Please ask for: Mrs D Johnson
Email: daun.johnson@arun.gov.uk
Telephone: 01903 737762
Our Ref: AL/27/20/PL
Your Ref:
Date: 1st April 2020

Application for Planning Permission

Development: Demolition of the existing dwelling & construction of 2 No. 2-bed, 3 No. 3-bed & 4 No. 4 bed houses including access, landscaping & associated works (resubmission following AL/51/19/PL).

Location: Springfield Hook Lane Aldingbourne PO20 3TE

Plot 2 and 3 Floor Plans 1:100@A3

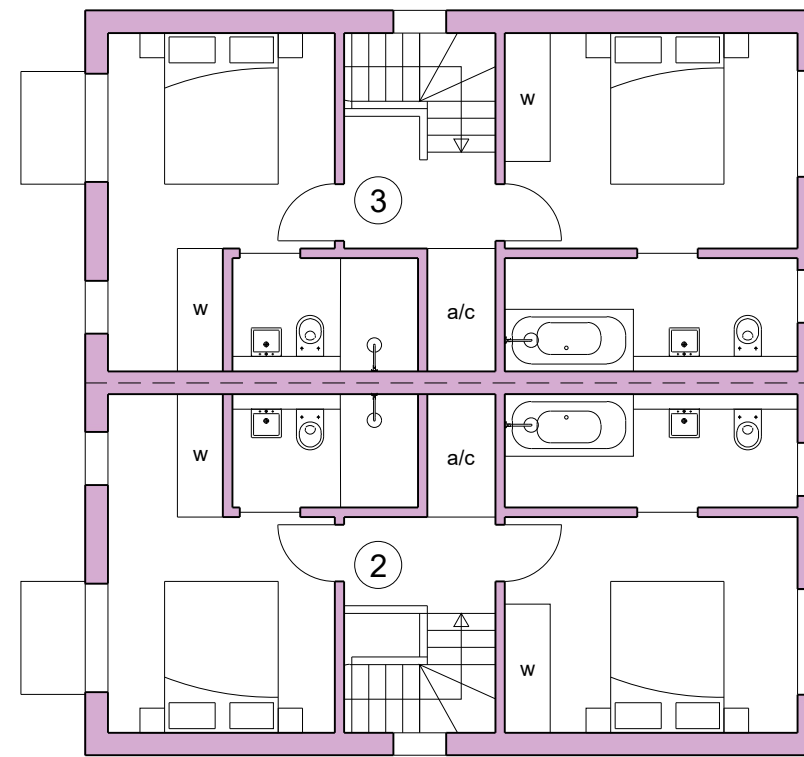
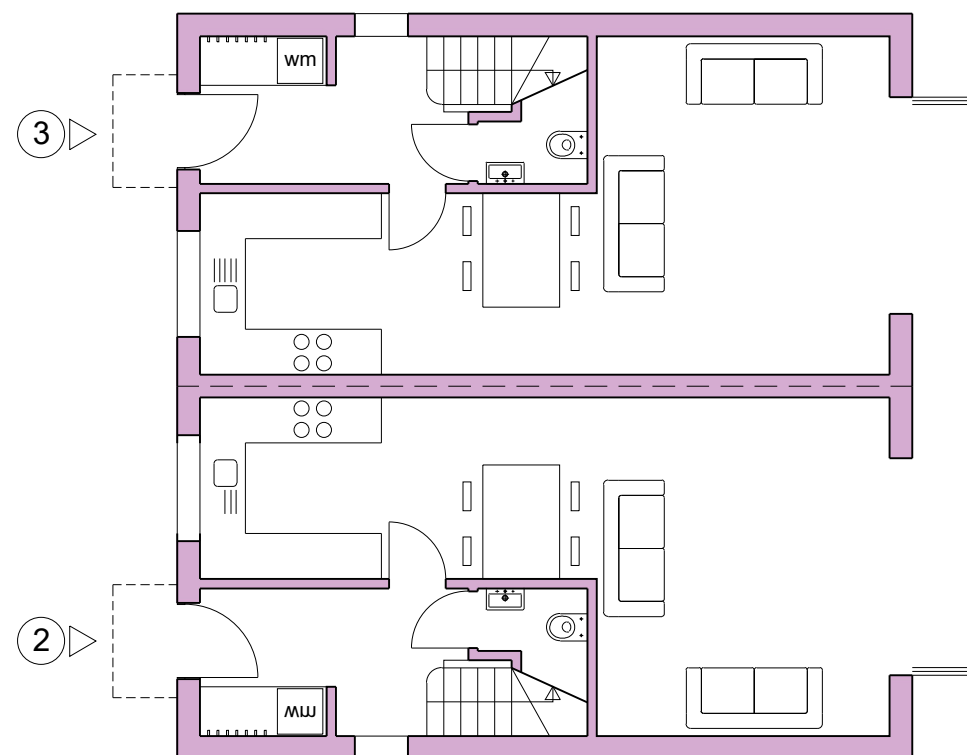
Please provide floor plans for plots 2 & 3.

Plot 6 Floor Plans 1:100@A3

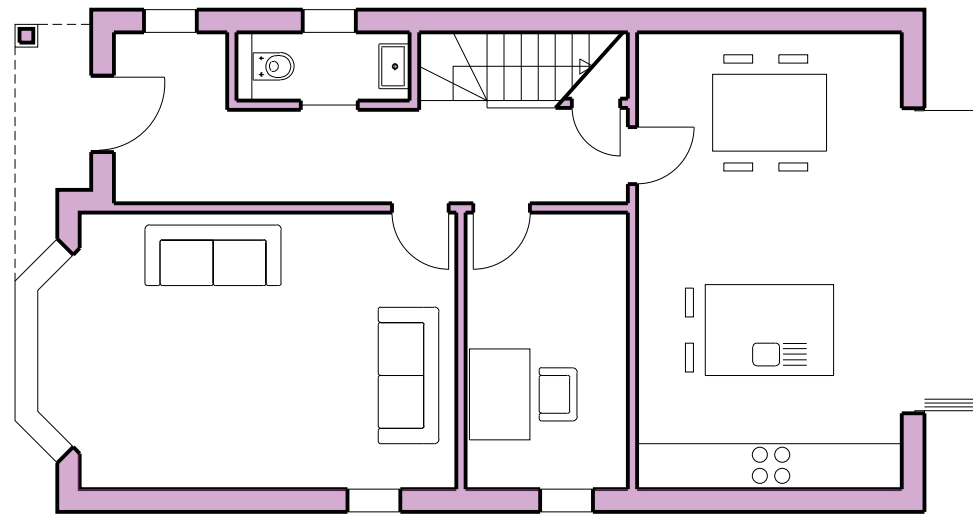
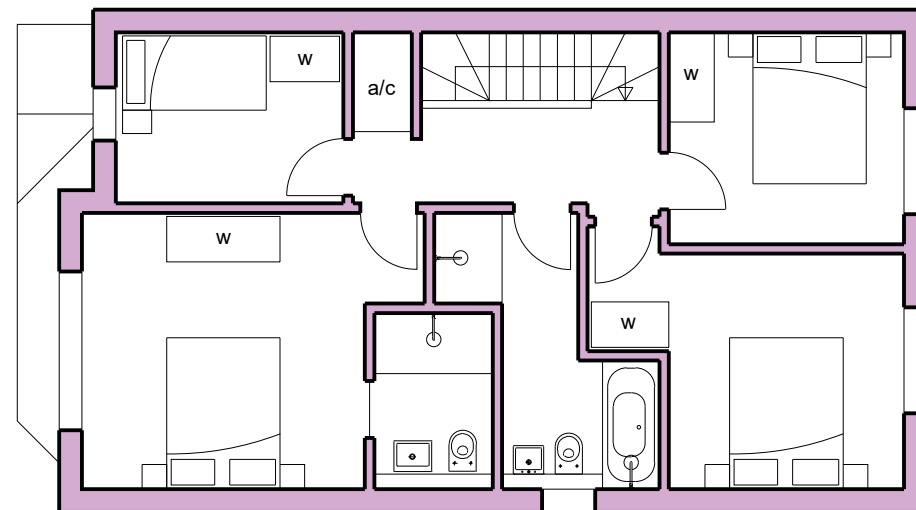
The floor plans have been labelled incorrectly for plots 6 & 7. Please amend accordingly.
Because the site falls within the Singleton and Cocking Tunnel, a Biodiversity Survey is required.
